25 November 2015

Our Ref: R/2015/19/A

RE: SSD 7064, Mixed Use Hotel, Residential and Retail Development, 175-177 Cleveland Street and 1-5 Woodburn Street, Redfern

GROUND / LEVEL 1 CONCEPT

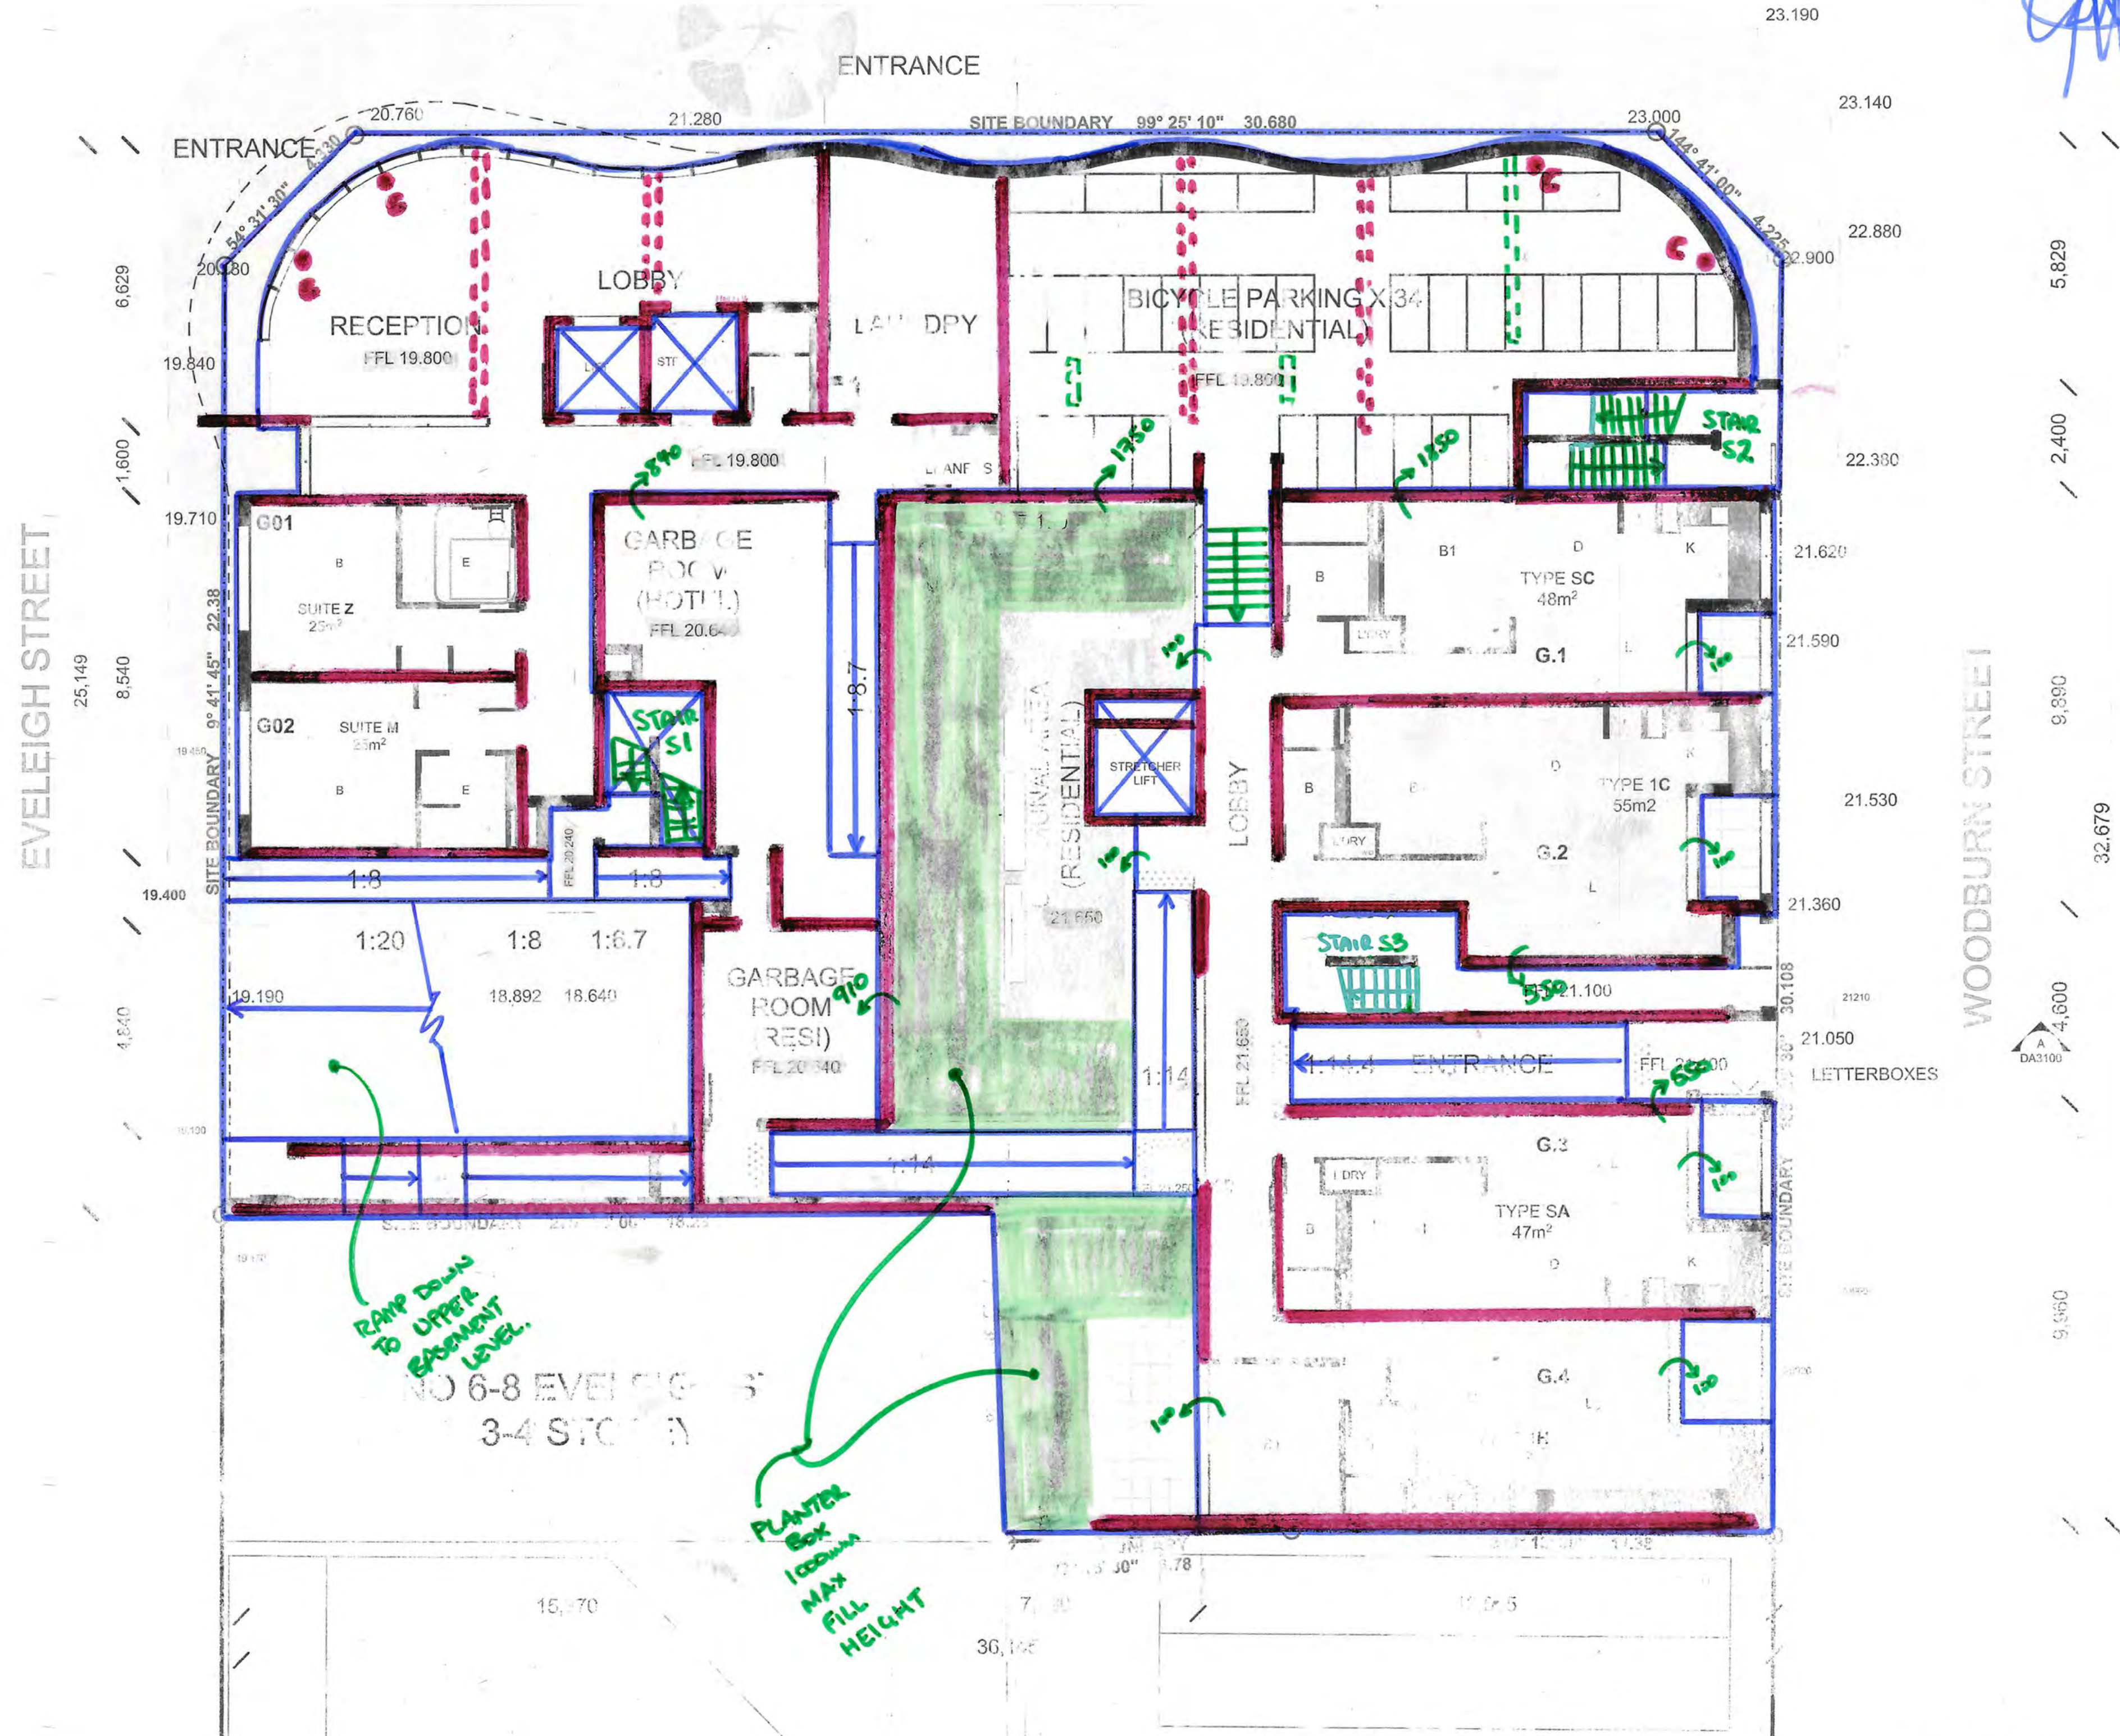
There are two hotel rooms proposed on Ground Level/Level 1 on Eveleigh Street that directly abut the street boundary. The rooms suffer from poor visual privacy as the windows have sill heights that could allow a passer-by to look in. They also provide poor acoustic privacy as they are located in between the carpark entry and hotel lobby.

A blade wall is proposed on the Eveleigh Street frontage that extends approximately 600mm over the boundary, leaving only 600mm for the footpath. This is an unacceptable intrusion into an already narrow footpath and City staff recommend it should be deleted. We also note that owner's consent from the City, as owner of the footpath, has not been provided.

To address these issues the City recommends that the applicant should consider providing retail uses on the ground floor instead of hotel rooms. Alternatively:

- a deep window recess could be considered to prevent looking in; or
- a landscape setback could be provided.

If the hotel rooms were to be approved, the consent authority should ensure the proposed windows have thick glass to ensure acoustic privacy.

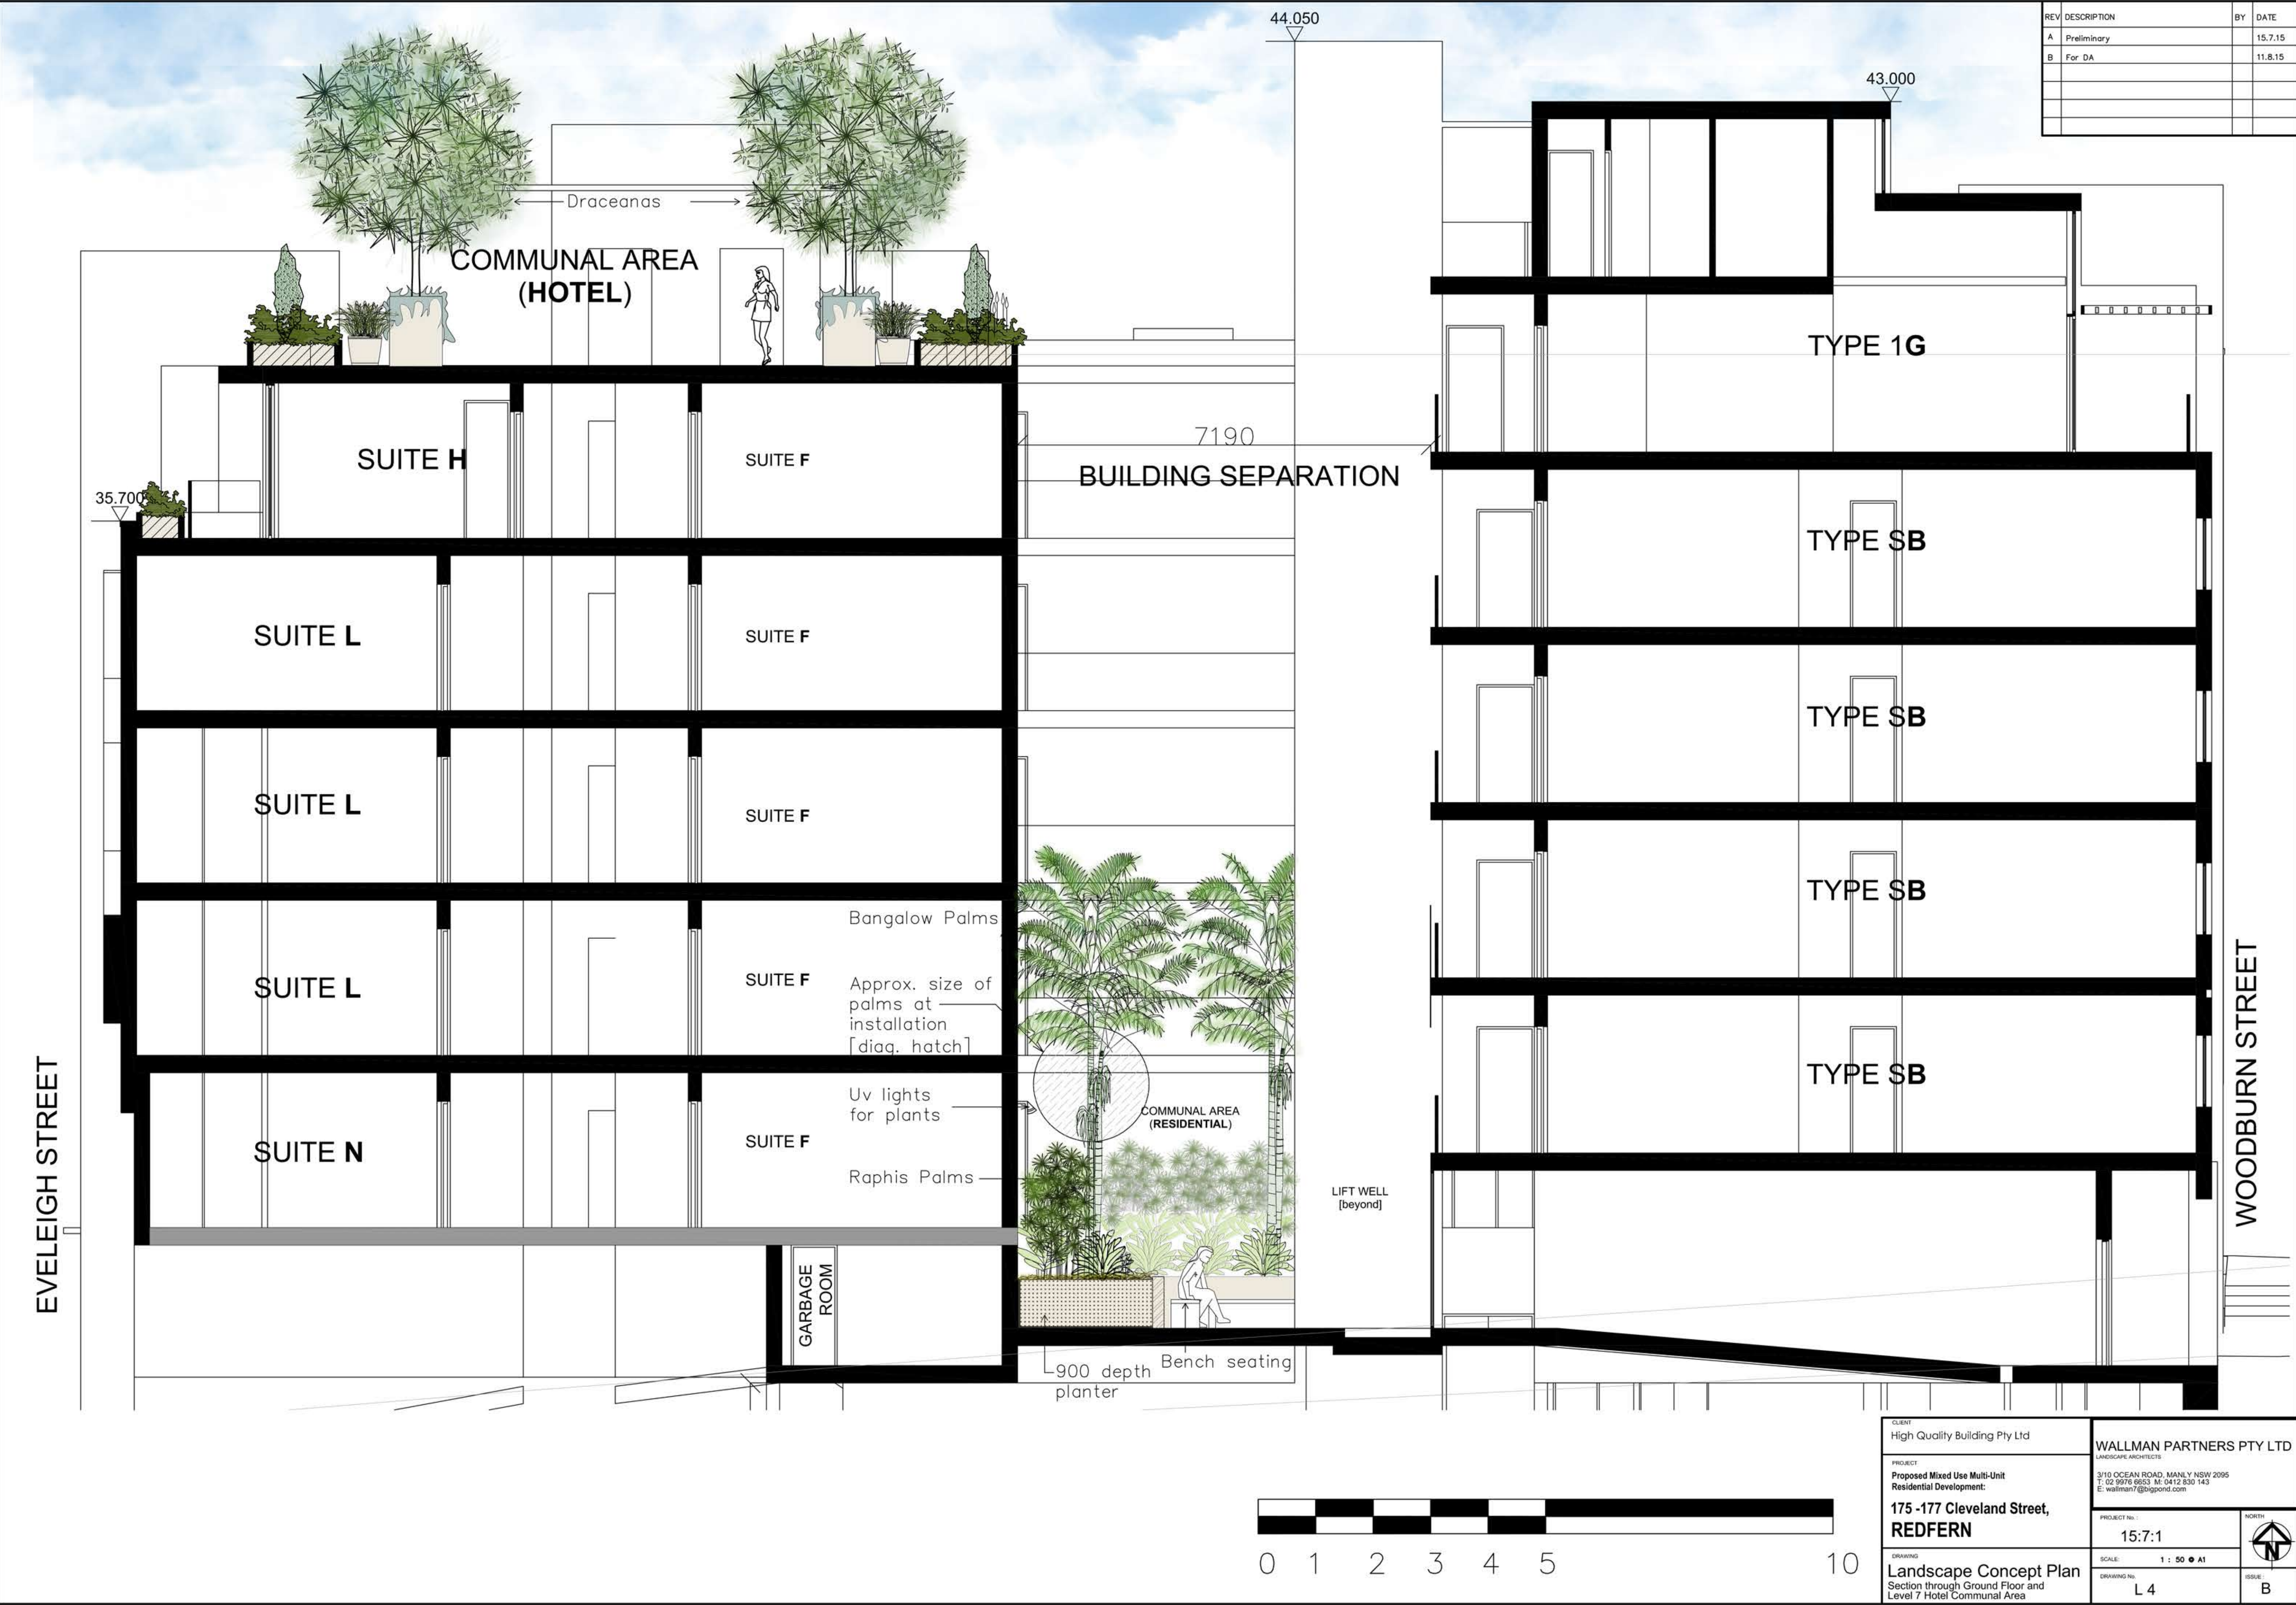
It is noted that the section on drawing L4 appears to illustrate a low planter to the outside edge of the roof terrace. The applicant should clarify how the

requirements of the BCA are met, and ensure all planting is positioned within the balustrade to allow unrestricted access for maintenance.
